April 5, 2018

**RE: Utility Trailer Sales
8201 Daytona Rd NW
Grading and Drainage Plan
Engineers Stamp Date: 3/27/18
Hydrology File: K09D026B**

Based on the information provided in your submittal received on 3/27/18, the grading and drainage plan cannot be approved until the following are addressed:

LEGEND

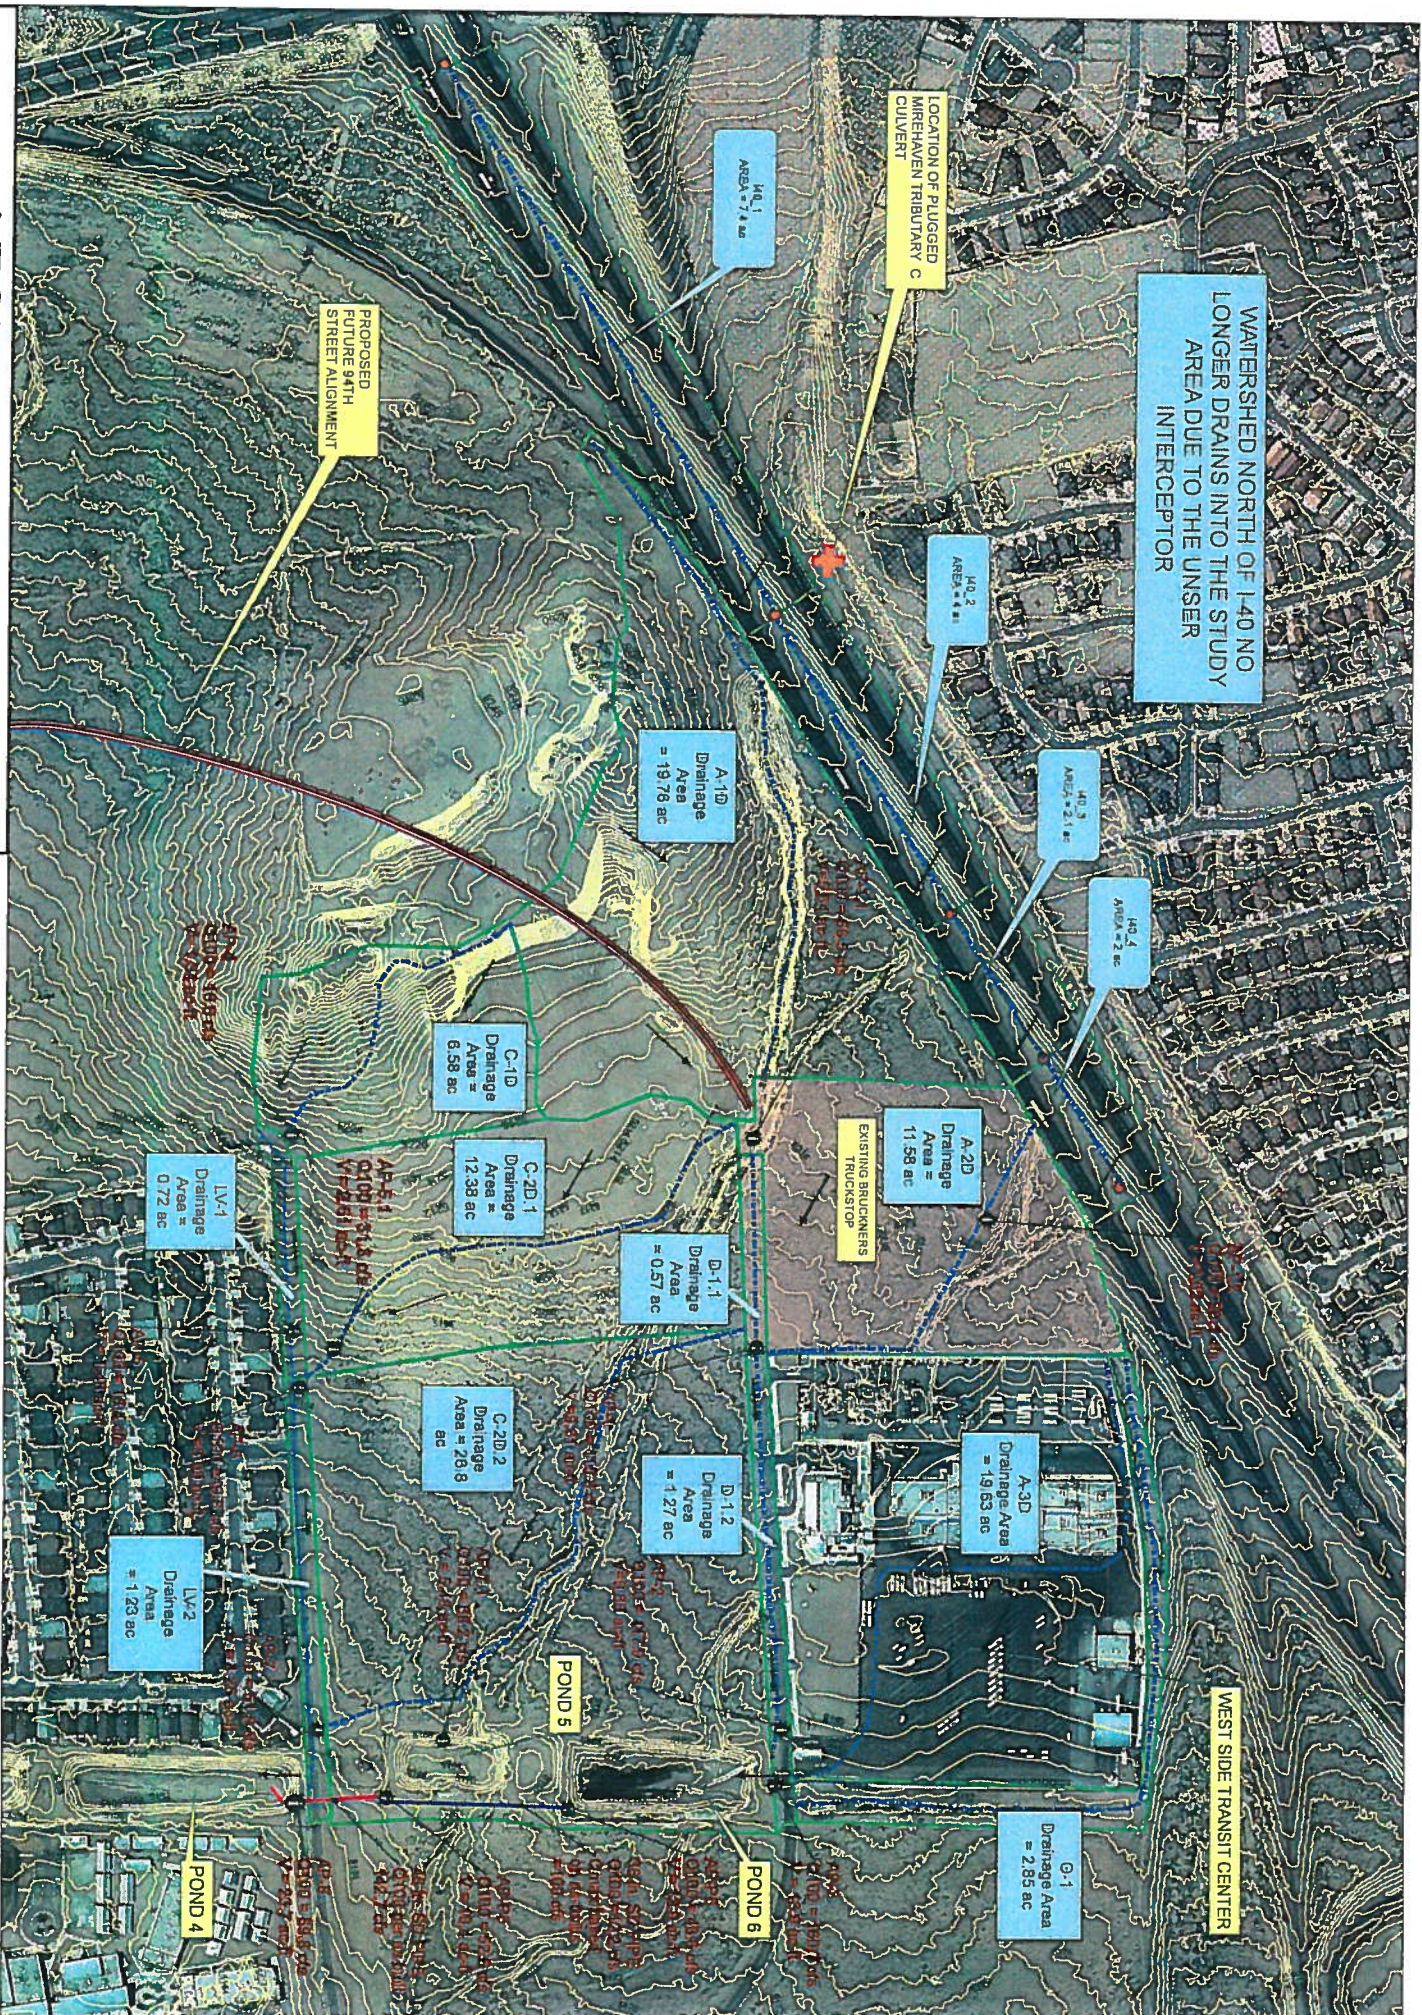
2. Provide the subbasin delineation map.
3. How are offsite flows from I-40 and remnant Mirehaven Arroyo being conveyed through your site?
4. If any work in the NMDOT ROW is proposed, then written concurrence must be obtained from NMDOT D3 Drainage. Please contact Tim Trujillo P.E (TimothyR.Trujillo@state.nm.us).

ENGINEER'S SEAL VINCENT P. CARRICA P.E. #16212	UTILITY TRAILER SALES ALBUQUERQUE NM GRADING AND DRAINAGE PLAN	DRAWN BY LA
	DATE 4/20/2018 2017041-GRADING	SHEET # C2 JOB # 2017041

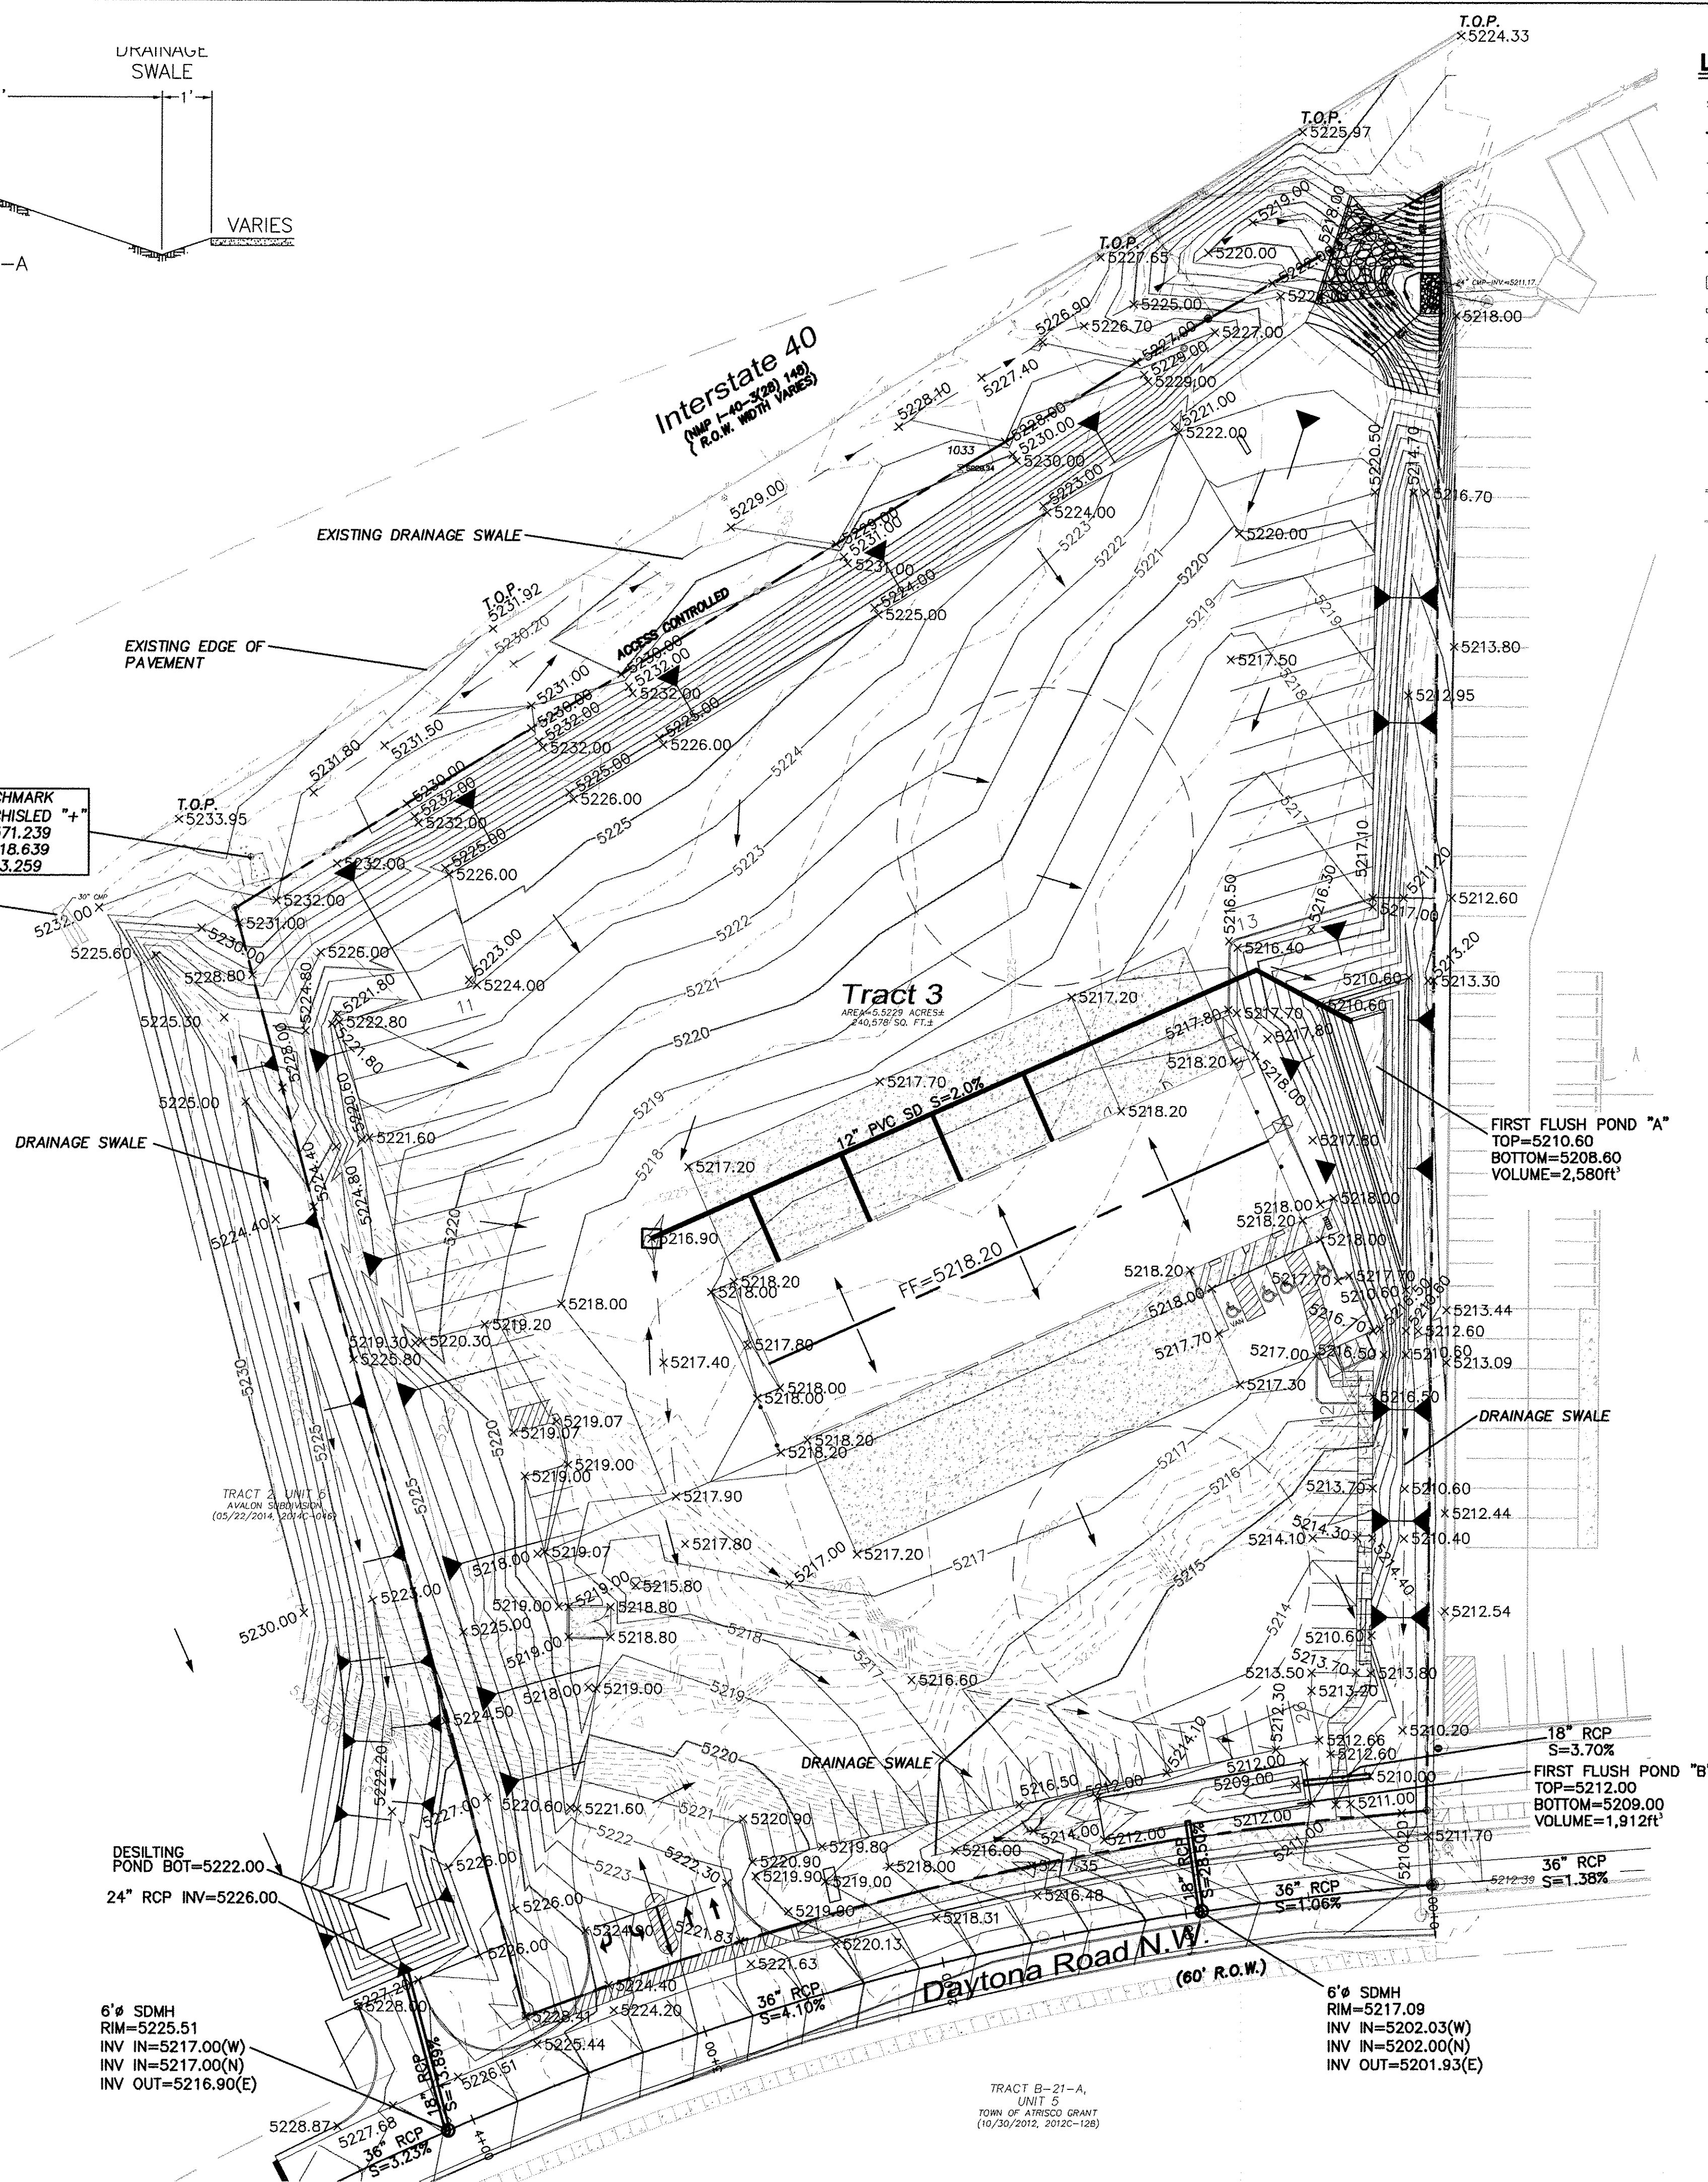
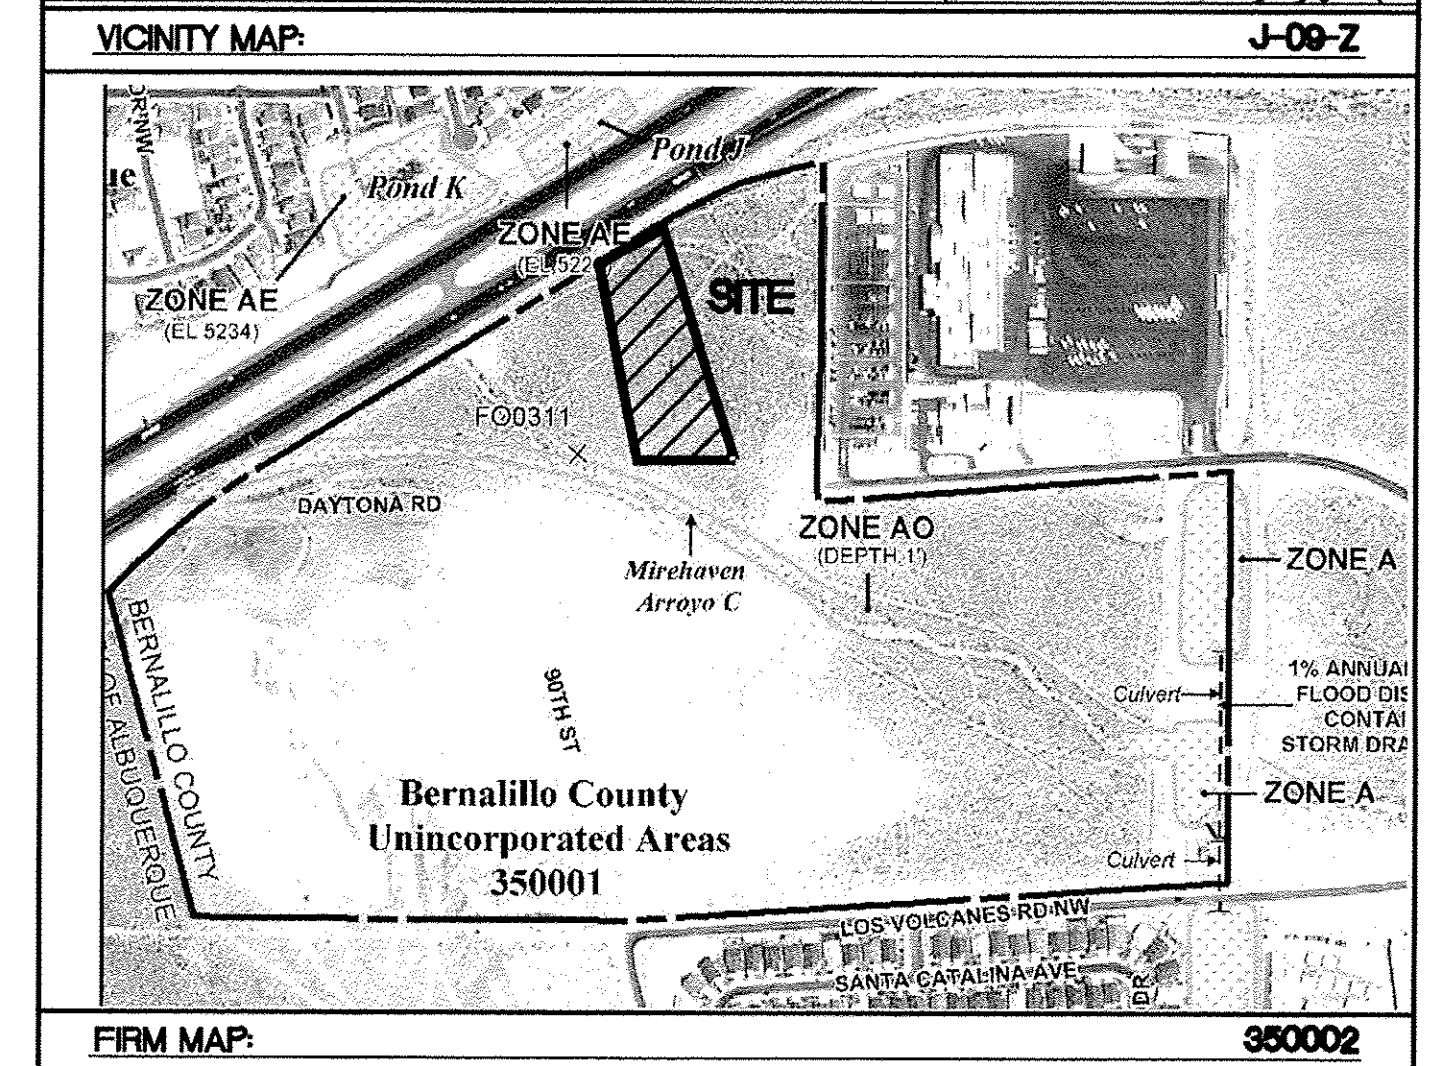
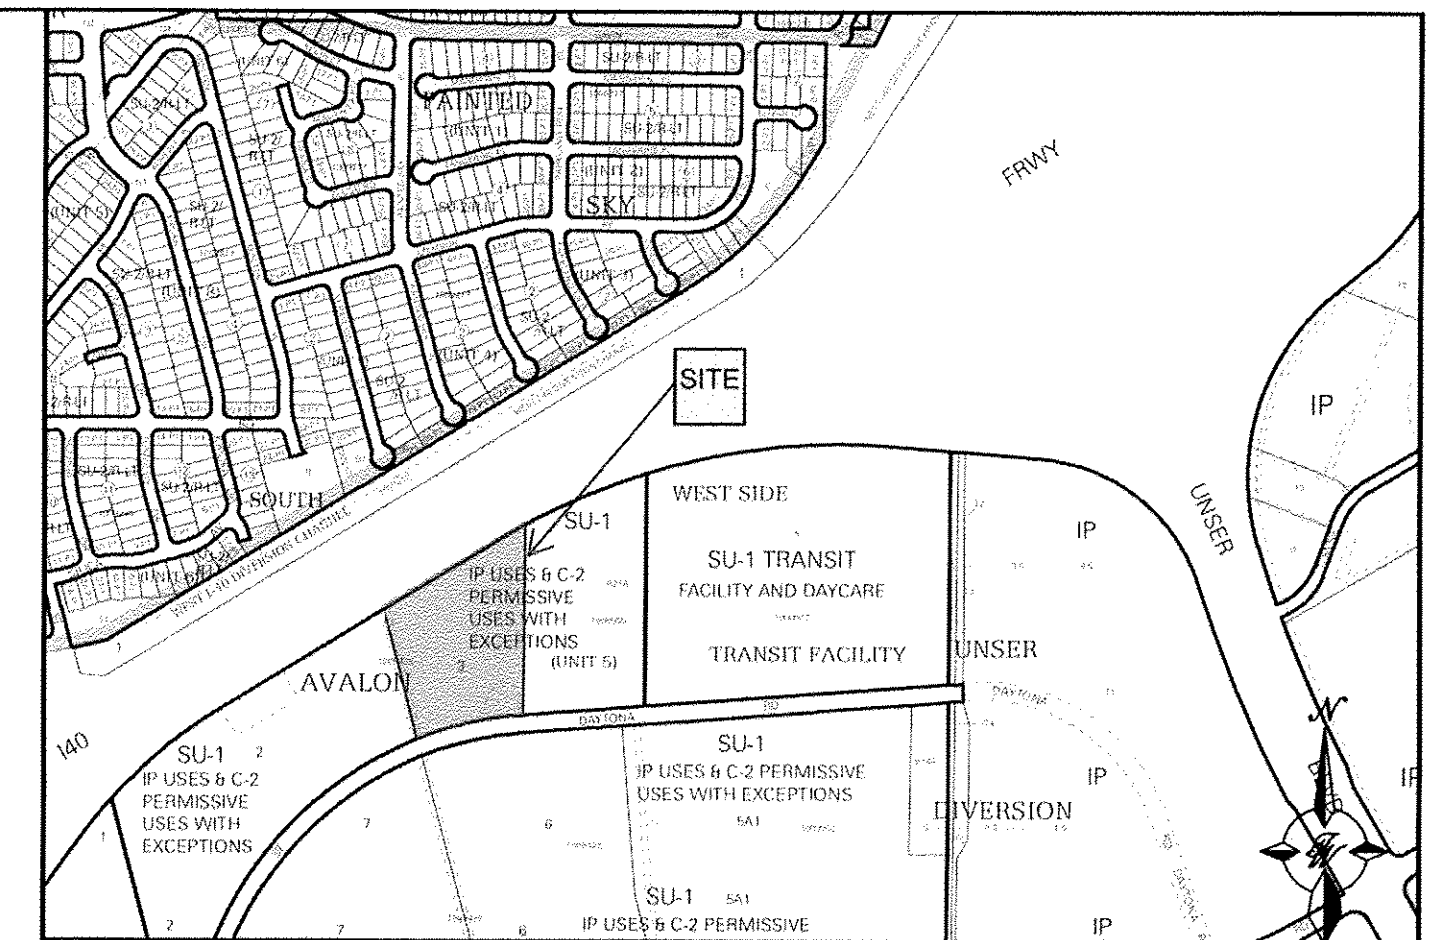
5. Clearly show on plans the limits of construction, areas of new impervious, existing and proposed topo.
6. All required drainage infrastructure improvements need to be sized and calculations provided; all improvements need to be shown on the plan. Adequate conveyance needs to be provided for the upstream developed conditions in accordance with the 2013 Amole-Hubbell drainage report.

8. Include project benchmark and datum.
9. Onsite first flush ponds and any other on-site drainage facilities need to be sized and hydraulic calculations provided.
10. Provide written permission from the adjoining property (Tract 2) for work on their property.
11. Either a recorded SIA with financial guarantee or close-out of the public work order will be required prior to final sign-off of the Site Plan.
